88 Waterloo Road,
Macquarie Park

Stormwater Management Plan

Project Ref: 0356

2 Response to Submissions

WATER QUALITY TREATMENT CHAMBER PLAN
SCALE 1:20

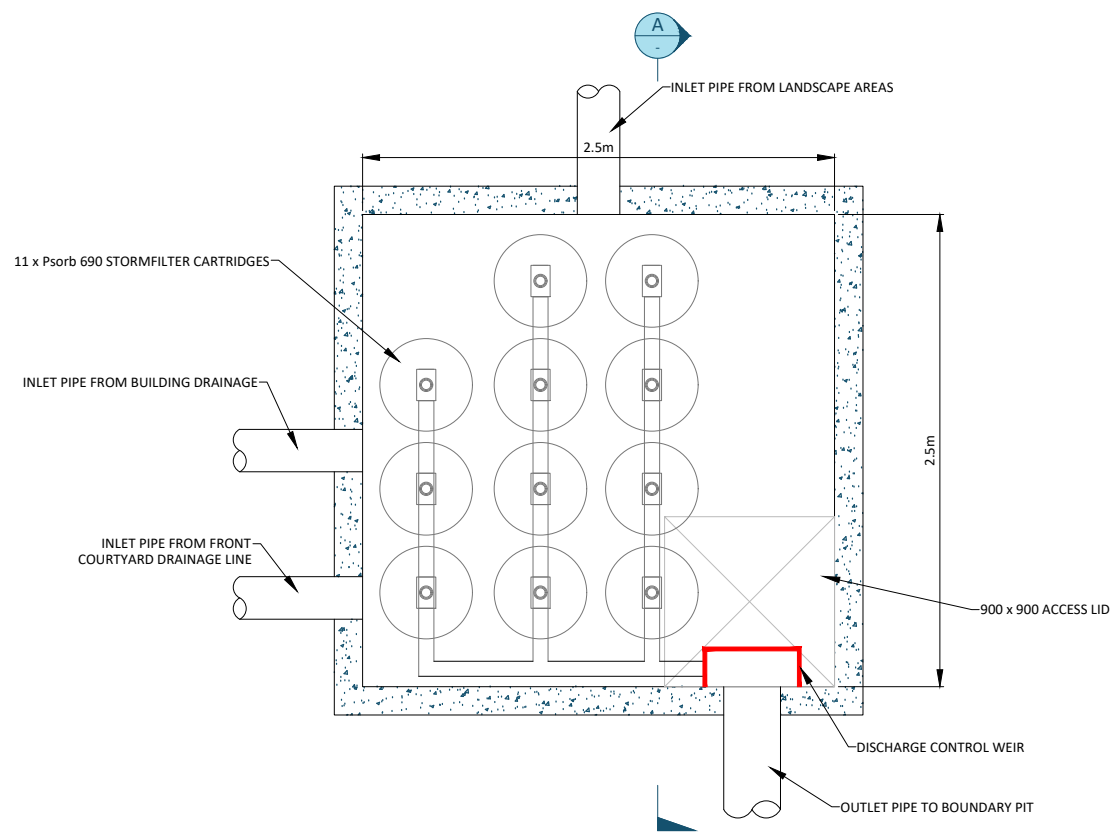
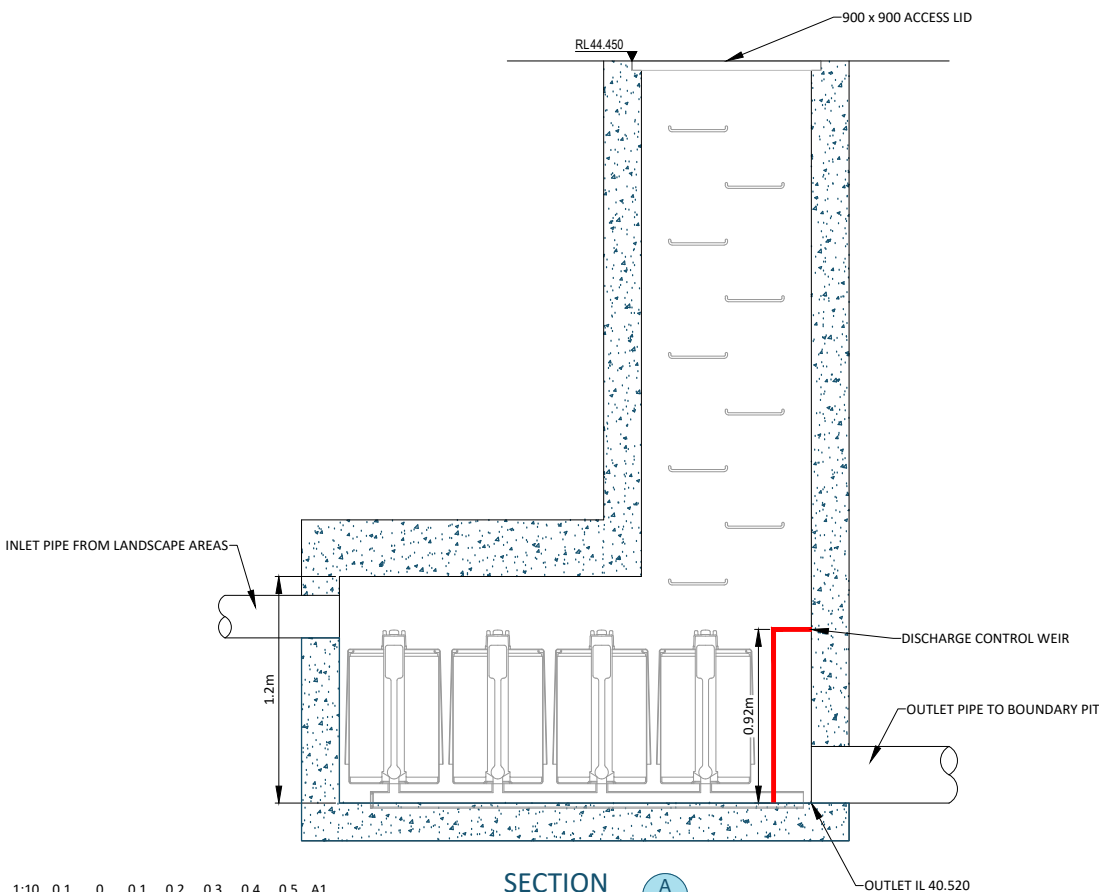
Submission	Response
The WSUD treatment tank is located at the lower end of the site and the base of this tank is marginally above the invert level of the kerb inlet pit into which it discharges to. Accordingly it is very likely that, in the event of a significant storm event, backflow will occur into the private drainage system. To resolve this requires elevating the WSUD tank so as to achieve a free draining system, warranting the base of the tank to be above the level of flood water in Cottonwood Crescent.	The outlet from the WSUD treatment chamber has been lifted to sit above the 100 year flood level in Cottonwood Crescent.
<i>Similarly any rising main will need to discharge to a surface inlet pit above flood levels, however this could readily be addressed by condition.</i>	The rising main has been lifted to discharge above the 100 year flood level in Cottonwood Crescent.
<i>Stormwater Management Plan to Be Provided and reflect the following: Details of the connection to Council pit/pipe shall be included in the Stormwater Management Plan.</i>	A cross section has been provided in drawing C-15 showing the proposed connection to councils drainage pit.
